**Paul Clarke** MRTPI | Chief Planning Officer | Communities and Place | Derby City Council, The Council House, Corporation Street, Derby, DE1 2FS | [REDACTED]  
[REDACTED]

### **A38 Derby Junctions - Interested Party comments**

I refer to the request by the Secretary of State (SoS) for Derby City Council (DCiC) to provide representations in relation to the re-determination of the quashed Development Consent Order (DCO) for the Derby Junctions Scheme, originally granted in January 2021.

FIGURE 7.6B
RETENTION OF
EXISTING VEGETATION
AND TREES

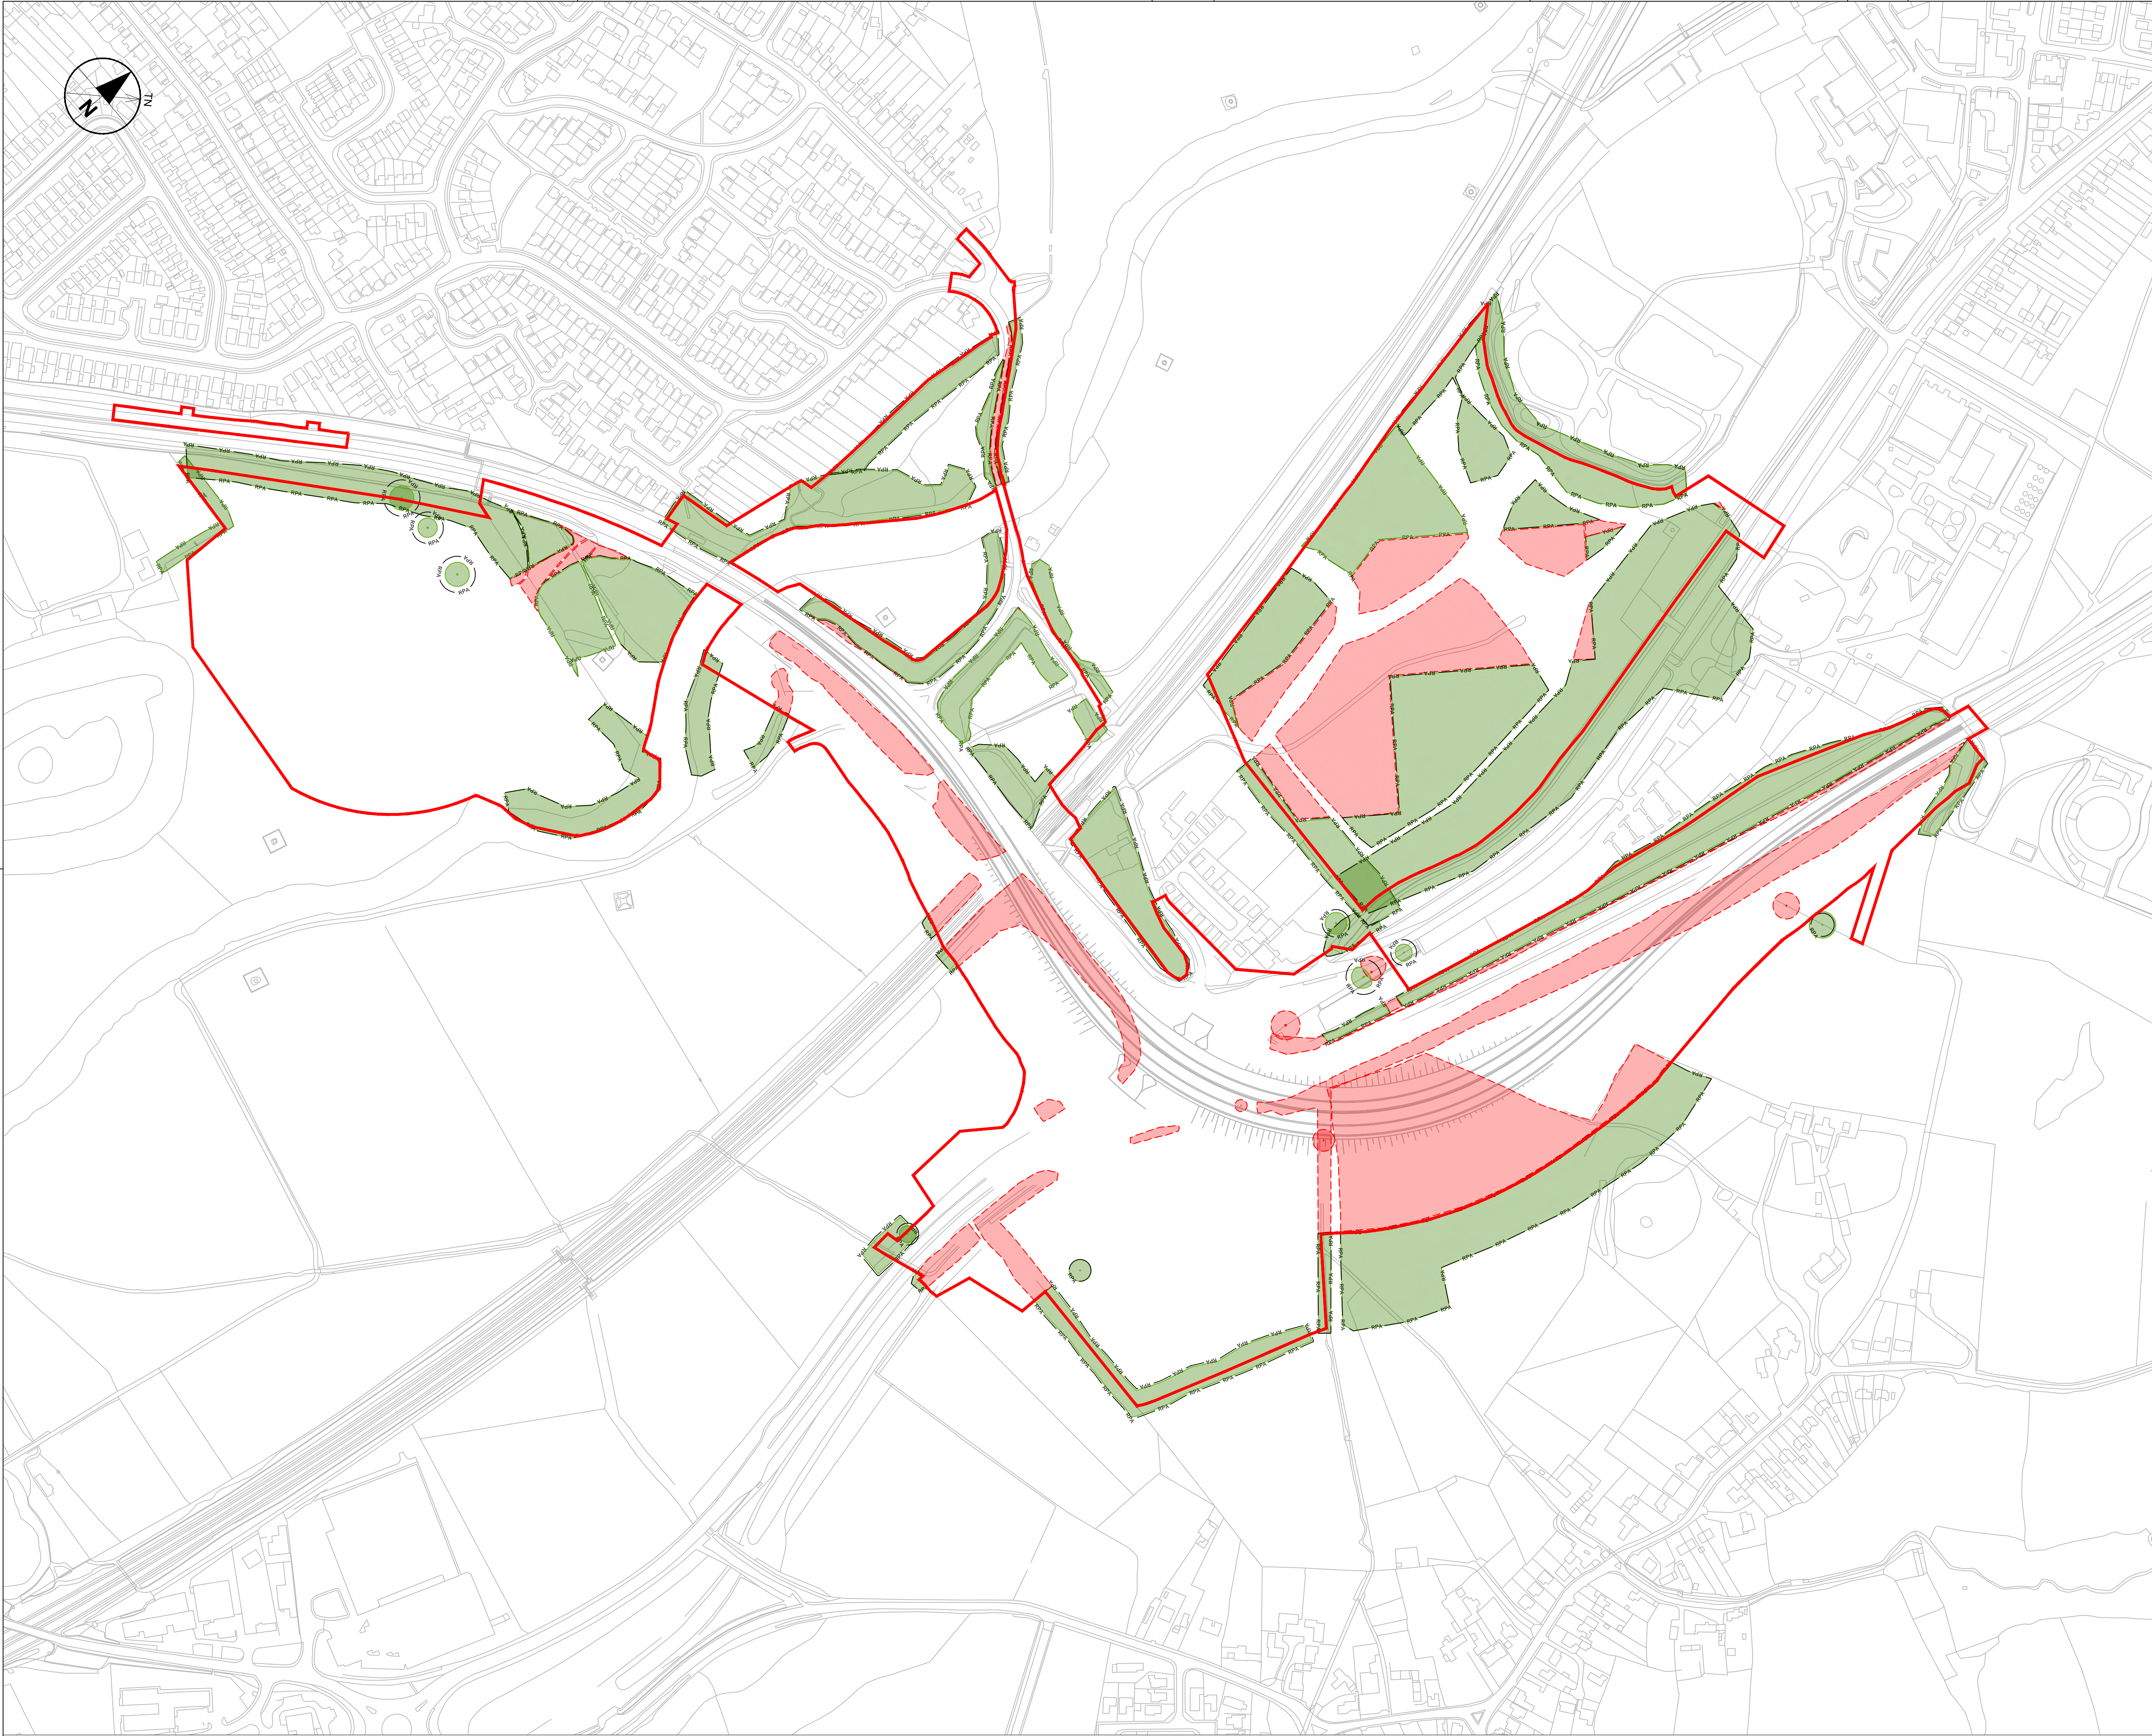
With regard to **section 8** and the potential impact on the veteran oak tree T358 there remains uncertainty on Highways England's part as to whether or not this tree will be retained. DCiC consider that the tree should be retained in situ. Veteran trees are irreplaceable habitats and impacts should in the first instance be avoided.

Figure 1: T358 Root Protection Area (RPA) Impacts - shows utility diversions and a drainage ditch within the RPA. Consideration must be given to relocating the utilities and ditch to limit the impact on the RPA.

DCiC do acknowledge that the tree's RPA will be seriously compromised. Following the anticipated loss of some of the RPA it is accepted that the tree would not be retained as a full canopy tree and that if retained it will need to be managed in a much-reduced state. Retaining the tree in a much-reduced state would retain much of the valuable habitat associated with veteran trees including the immediate soil habitat with associated mycorrhizal associations. This soil habitat would be lost if the tree was felled, and the trunk installed in Markeaton Park as a totem (habitat) pole. If retained in a reduced state it may need to be subject to periodic static pull tests to confirm that it is safe to retain. The statement does not mention any proposed works to manage the tree in a reduced state.

Further detailed assessment is required to determine if the tree can be retained, albeit in a reduced state. The detailed assessment must include a tree works management plan. The councils tree section and the TPO officer must be consulted during the detailed assessment.
